From: Andrew Wood <Andrew.Wood@arun.gov.uk>
Sent: 07 August 2020 12:40
To: Planning.Responses <Planning.Responses@arun.gov.uk>
Subject: FW: FW: A/77/20/DOC

Subject: A/77/20/DOC

Having reviewed this application with a colleague we can confirm that we do not recommend discharge of conditions 8 and 9 at this time. We have the following comments which require addressing:

CLIENT	TL Homes		
PROJECT	Old Blacksmiths Yard Water Lane Angmering		
TITLE	Proposed Drainage and Levels Layout		
DRAWN	DATE	PROJECT NO.	22346
M Pacifico	July 2020		
ENGINEER	CHECKED	DWG. NO.	
S Doughty		REV.	
SCALE	1:100 @ A1

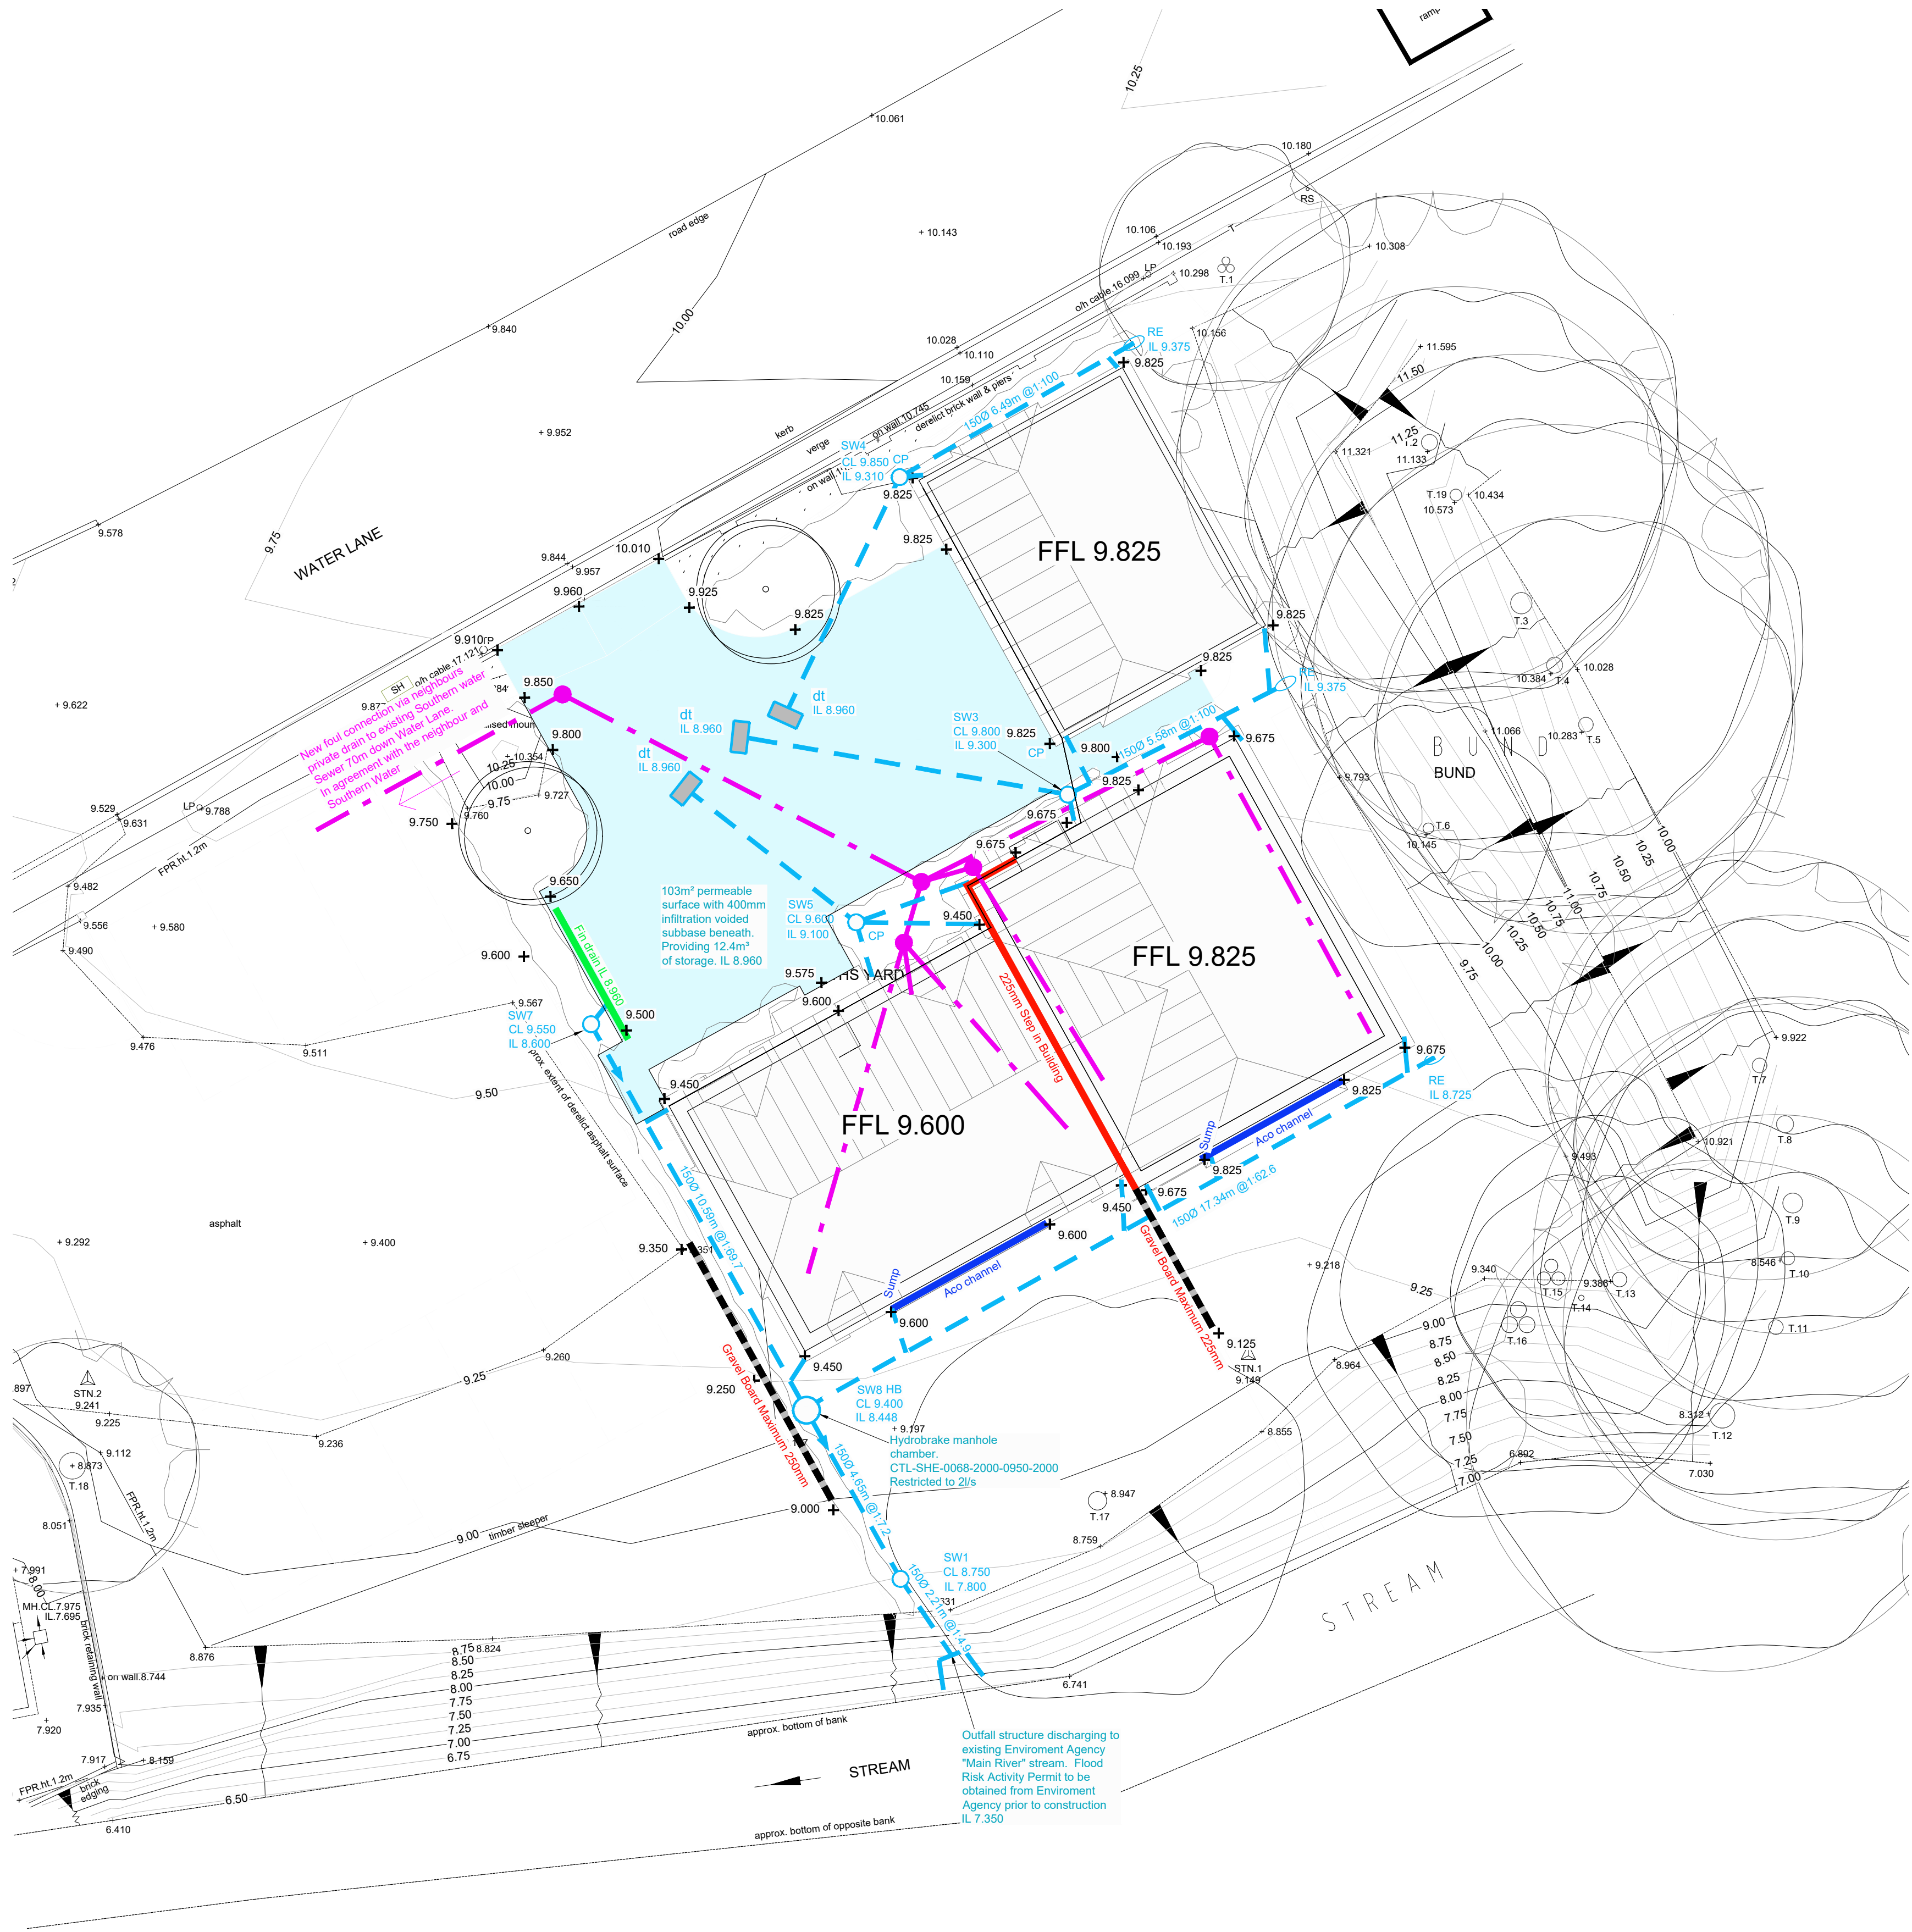
4. The drainage strategy layout is cramped and not clear. Please provide a plan that is to scale and includes the following additional features; a) pipe materials and dimensions for all pipes b) invert levels of diffuser blocks and fil drain c) cover levels and cover types of all inspection chambers/manholes d) finish levels of permeable paving (we note that two ground levels are stated, please make it clear if these are proposed ground levels and include a further level near the garage)

7. The layout states the hydrobrake will have a design head of 0.5m, this is inconsistent with the calculations and construction details. Please correct.

4. The drainage strategy layout is cramped and not clear. Please provide a plan that is to scale and includes the following additional features; a) pipe materials and dimensions for all pipes b) invert levels of diffuser blocks and fil drain c) cover levels and cover types of all inspection chambers/manholes d) finish levels of permeable paving (we note that two ground levels are stated, please make it clear if these are proposed ground levels and include a further level near the garage) We have taken on this project and provided a new set of drawings and details which we trust are clear.

7. The layout states the hydrobrake will have a design head of 0.5m, this is inconsistent with the calculations and construction details. Please correct. We have detailed a bespoke hydrobrake for the project and the model and details provided are all consistent.

PERMEABLE BLOCK PAVING DRIVE CONSTRUCTION
VOIDED SUBBASE TANKED SYSTEM
(Scale 1:20)

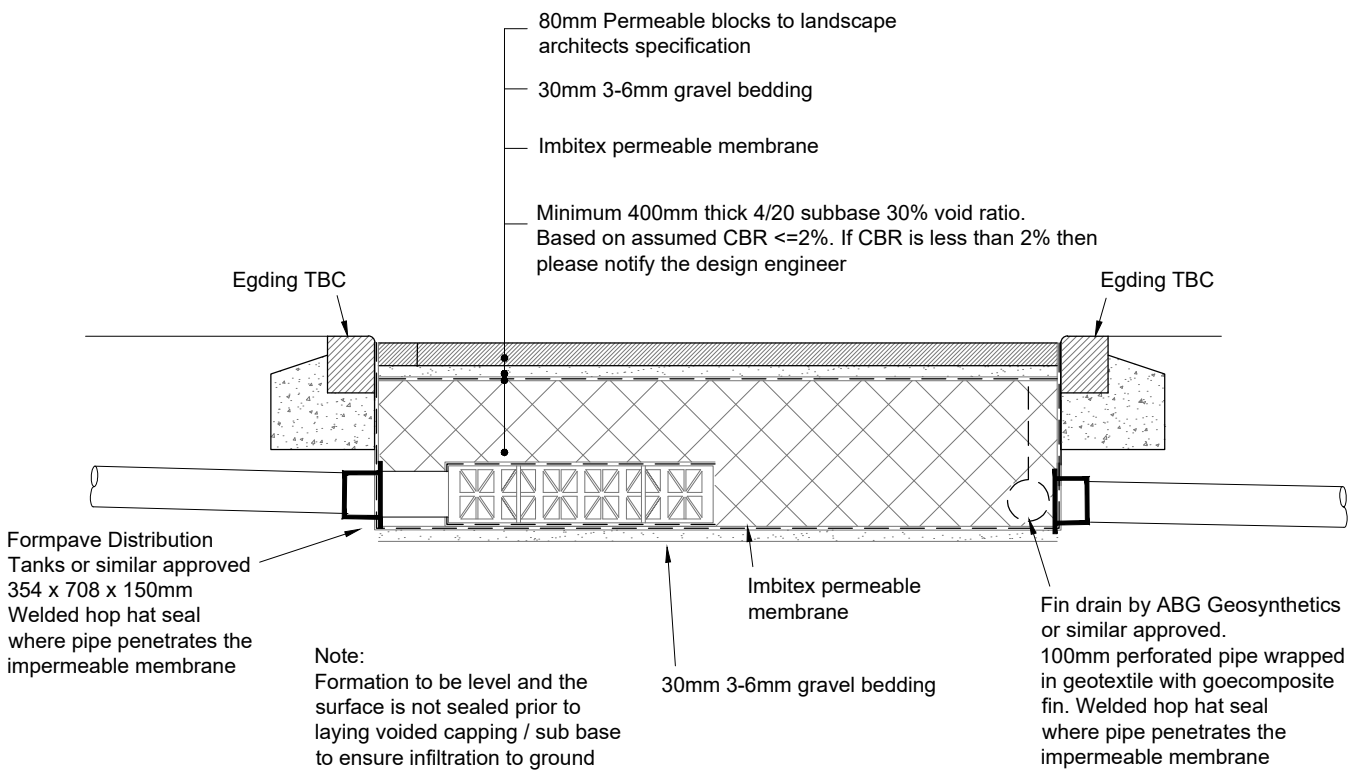
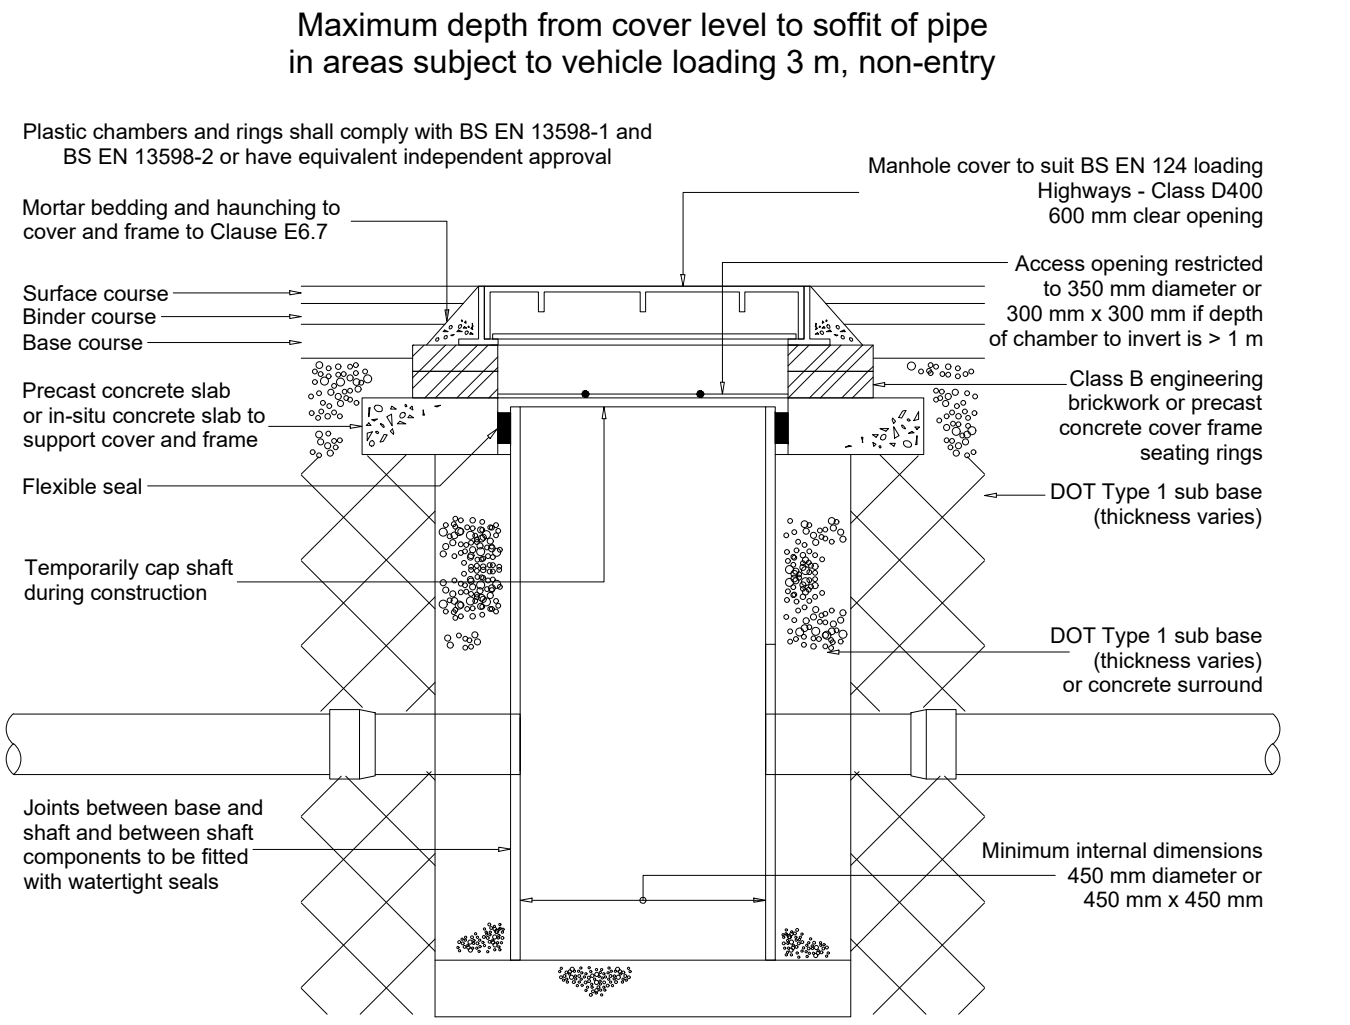
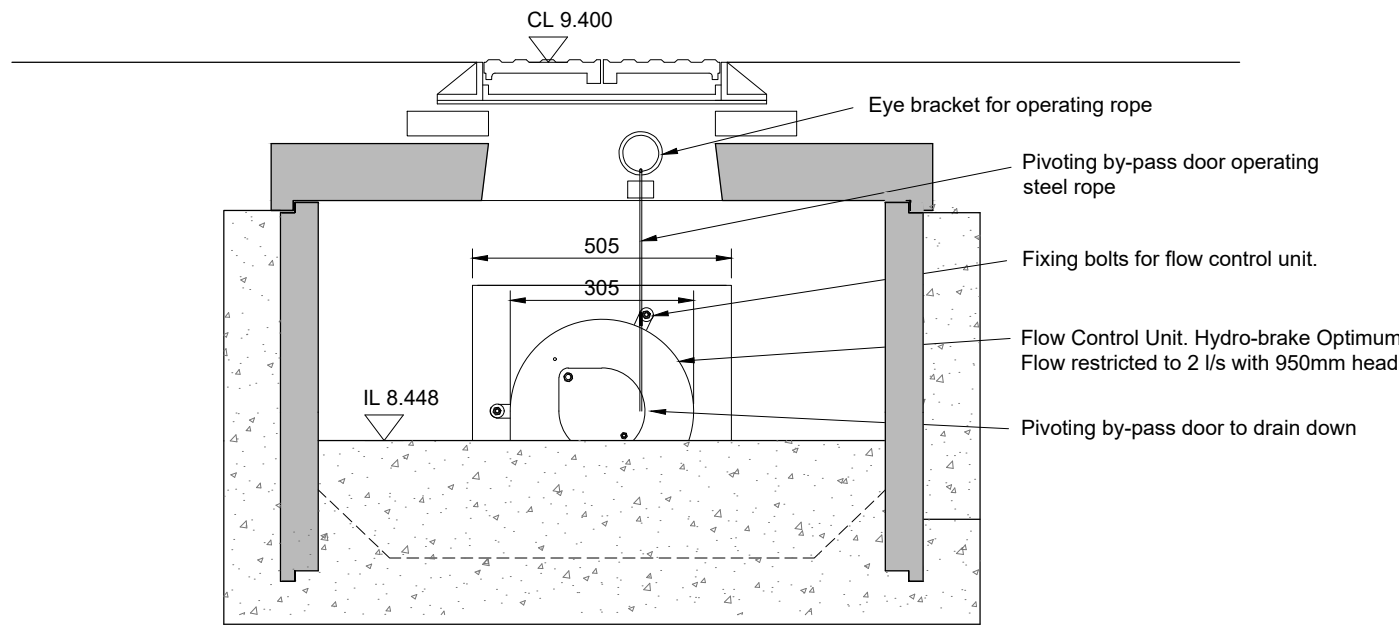
10. Please provide construction detail drawings of permeable paving, aco channel, manholes and catchpits. The permeable paving detail currently provided is not site specific and lacks material specification detail.

Thanks for the comments below, I attach drawing 501A which we have included the fin drain construction detail on to the permeable block detail as requested and updated the level information to the hydrobrake Construction Detail. The invert has been updated to 8.448 to reflect the layout design. Drawing 101 remain unchanged but I have attached for ease of reference

10. Please provide construction detail drawings of permeable paving, aco channel, manholes and catchpits. The permeable paving detail currently provided is not site specific and lacks material specification detail. Provided on Drawing 501.

MANHOLE SW11 - HYDROBRAKE
(Scale 1:20)

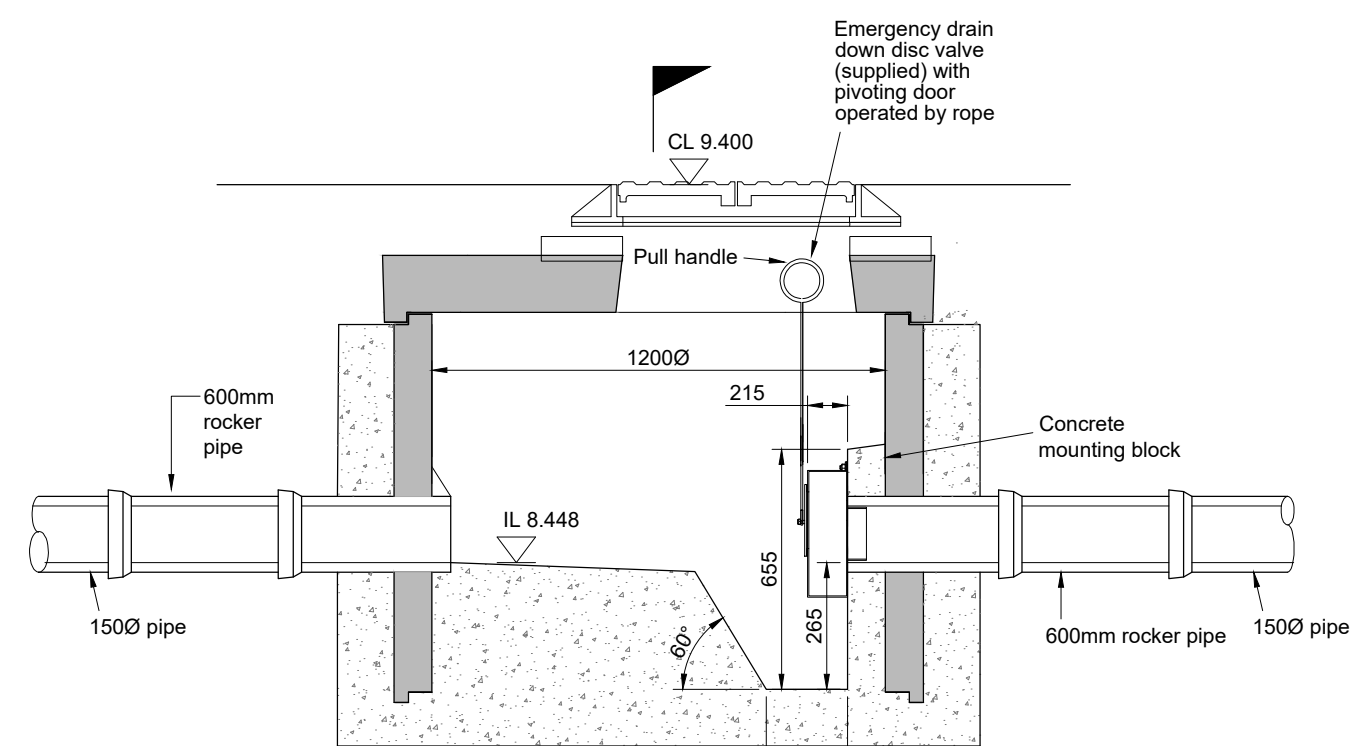
1. The construction detail for the hydrobrake has some inconsistencies, specifically invert level and design head. Please correct.
2. Please can you also provide a construction detail drawing for the Fin Drain.

8. The hydrobrake construction detail needs to be site specific, i.e. include invert levels and cover levels. Step rungs should also be provided.
9. Please provide pipe bed and surround details that are consistent with approved document H.

The design head on the calculations is set at 950mm to prove the system before the hydrobrake manhole will overtop.

8. The hydrobrake construction detail needs to be site specific, i.e. include invert levels and cover levels. Step rungs should also be provided. We have detailed a bespoke hydrobrake for the project and the model and details provided are all consistent. We have not provided step rungs to this chamber as we do not wish to encourage access.
